Rezoning Transportation Analysis

Petition Number: 2021-100

General Location Identifier: 02761107

General Review Information

CONCEPT
SITE PLAN

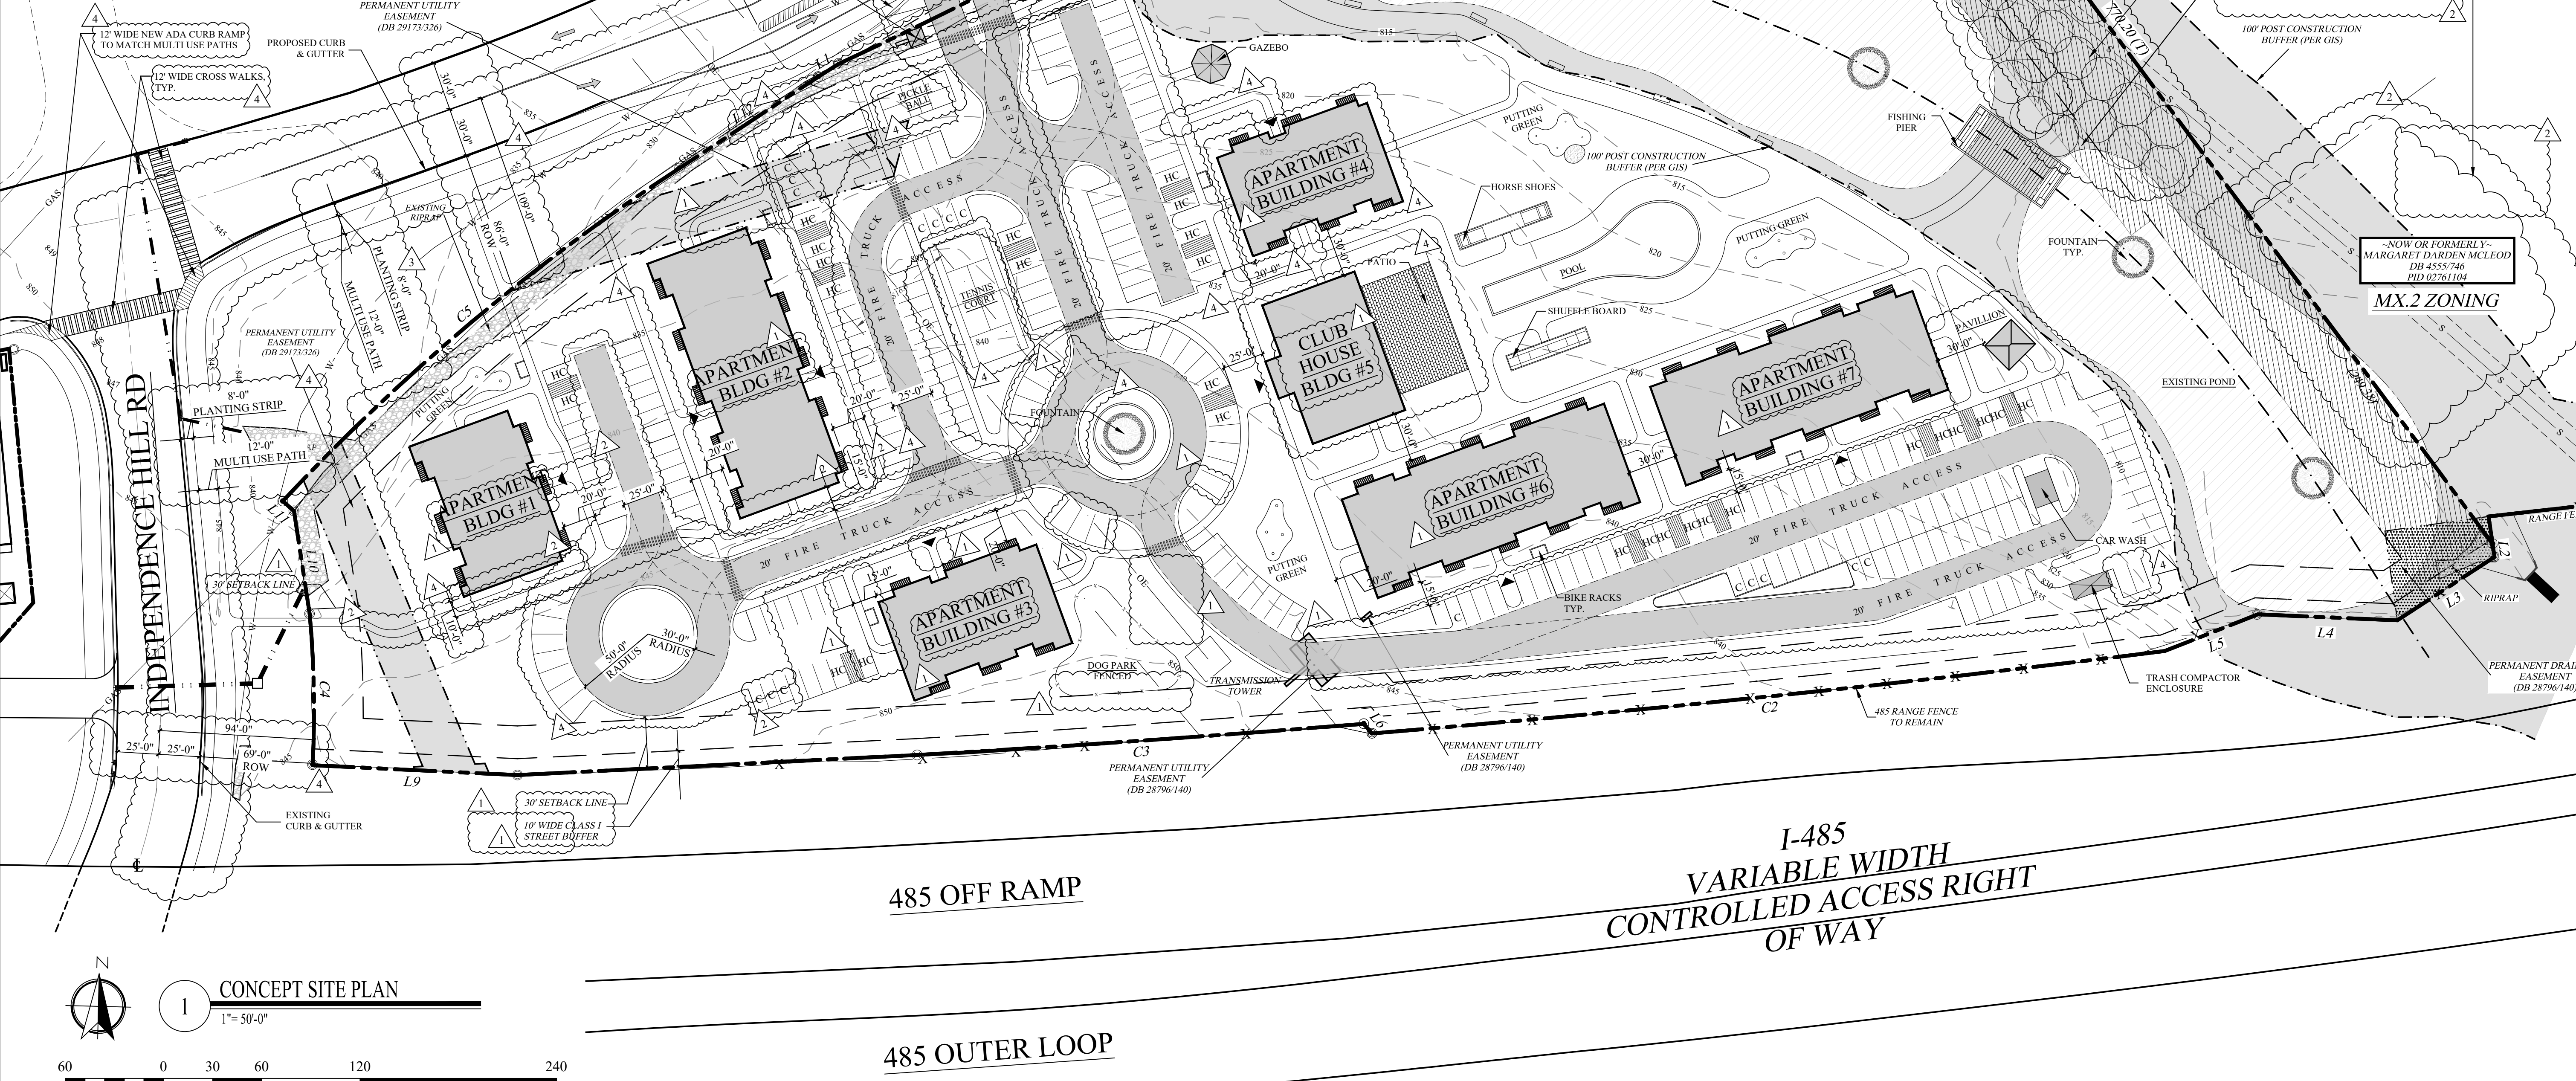
- Outstanding Comment from 9-22-21:** The curbline along Eastfield Road shall be shown at 30' from centerline to back of curb. Revise site plan to reflect this condition and label and dimension the right-of-way and curb and gutter from the Eastfield Road centerline.

- Outstanding Comment from 9-22-21:** Revise site plan and conditional notes to label and describe location of the existing curb location and right-of-way along Independence Hill Road. The site plan shall label and dimension the curb and right-of-way from the road centerline.

- Revise site plan to construct 8-foot planting strips and 12-foot multi-use paths on Eastfield Road and Independence Hill Road. The site plan shall label and dimension both items from the back of curb and gutter and road centerline. Add conditional note committing to construction and maintenance of the 8-foot planting strips and 12-foot multi-use paths on Eastfield Road and Independence Hill Road since property is in the ETJ. A maintenance agreement will be required for these facilities.
Clarifying Comment from 9-22-21: Current plan shows 6' back of curb sidewalk along Eastfield and Independence Hill Roads. Revise site plan and add conditional note to construct 8-foot planting strips and 12-foot multi-use paths on Eastfield and Independence Hill Road frontages. Two new curb ramps will be need to be constructed on the southeastern corner of Independence Hill Road and Eastfield Road at a width of 12' for each to match the MUP's. Add conditional note committing to construction and maintenance of these facilities.

- Revise site plan and add conditional notes showing access points off Eastfield Road and Independence Hill Road to be right in-right out only.
Clarifying Comment from 9-22-21: Per email dated 09-28-2021 from Wendy Taylor, a 100' RTL and 150' LTL were added for the access point off Eastfield Road. Show existing striping on Eastfield Road and show the existing LTL taper shortened from Eastfield Road to Independence Hill Road and create a striped section separating the two LTLs.
